Goulburn Mulwaree Council
Locked Bag 22
Goulburn NSW 2580

15 August 2025

**Subject: Gundry Solar Farm (SSD 48225958)
Review of Response to Submissions & Amendment Report**

WINDELLAMA ROAD

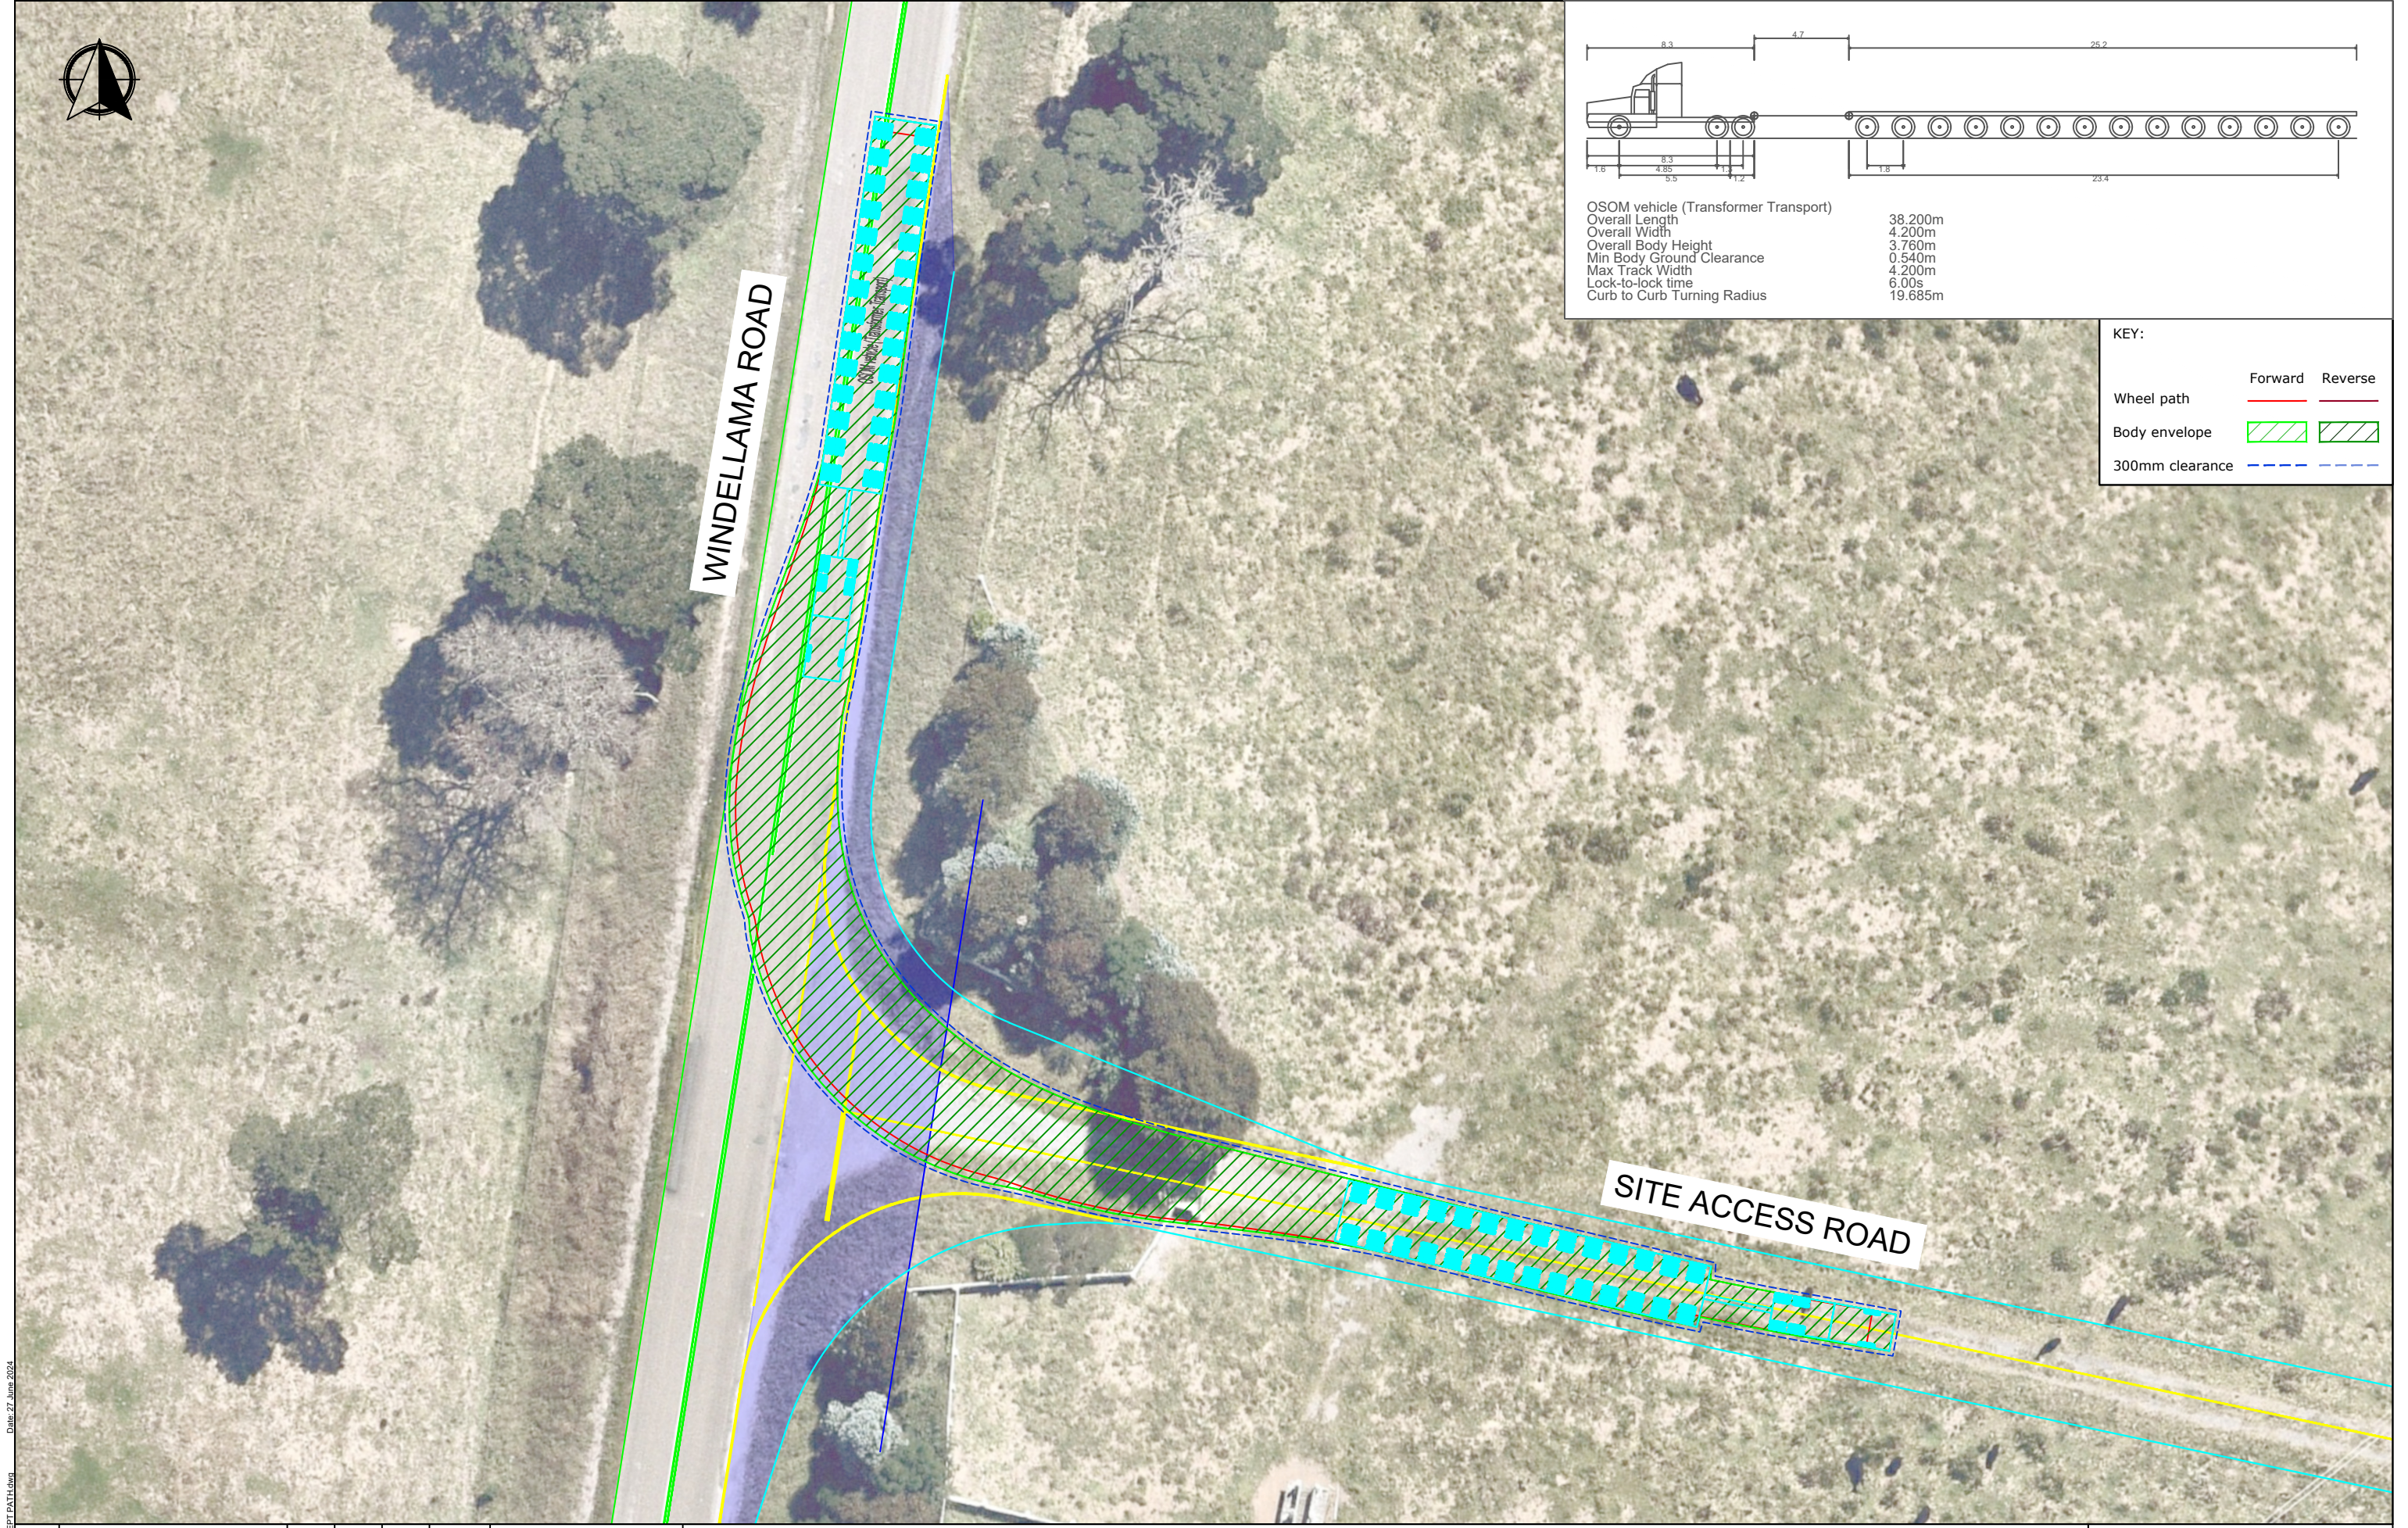
3. Access to the development site is proposed by an upgraded entry at the existing property entrance, 961 Windellama Road. As the majority of traffic during the construction and operational phases of the project will be to and from Goulburn, a Basic Left Turn (BAL) treatment is proposed and is considered appropriate. Safe Intersection Sight Distance (SISD) is available on each approach to the entry point. It is proposed to construct the upgraded entry at the commencement of the project to facilitate heavy vehicle turning movements. A Section 138 Roads Act 1993 application with accompanying design plans is required to be lodged with Council as the Road Authority for assessment prior to commencement of construction.
